STRIDE & SON

20th July 2012.

Re: 9 Viscount Drive, Pagham P021 4PE
Planning Application No. P/54/12

PROPOSED REAR ELEVATION

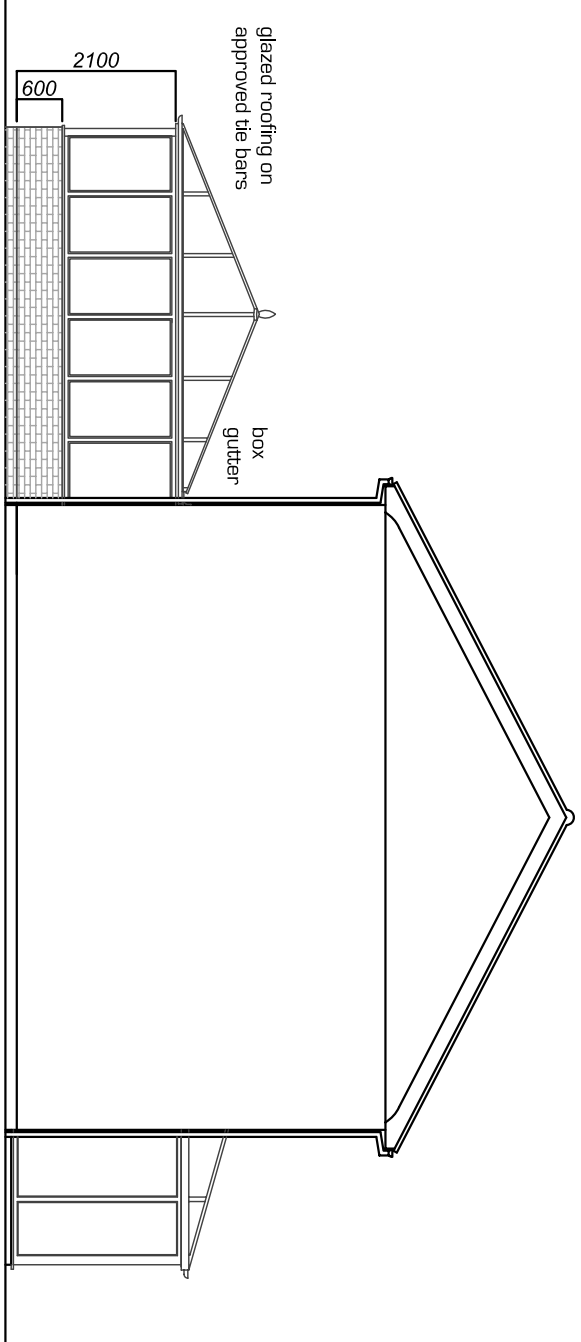
Works are also intended to the rear elevation with patio doors and a change of the cladding. Again our only concern would be about any overlooking to our clients' property but note that it is intended to fit Juliette balconies, and from a practical point of view it would be impossible to step out on to the box gutter and glazed roof of the conservatory.

This is our only concern on behalf of our client who would not want to see any balcony here in any form which would cause overlooking of our clients' garden.
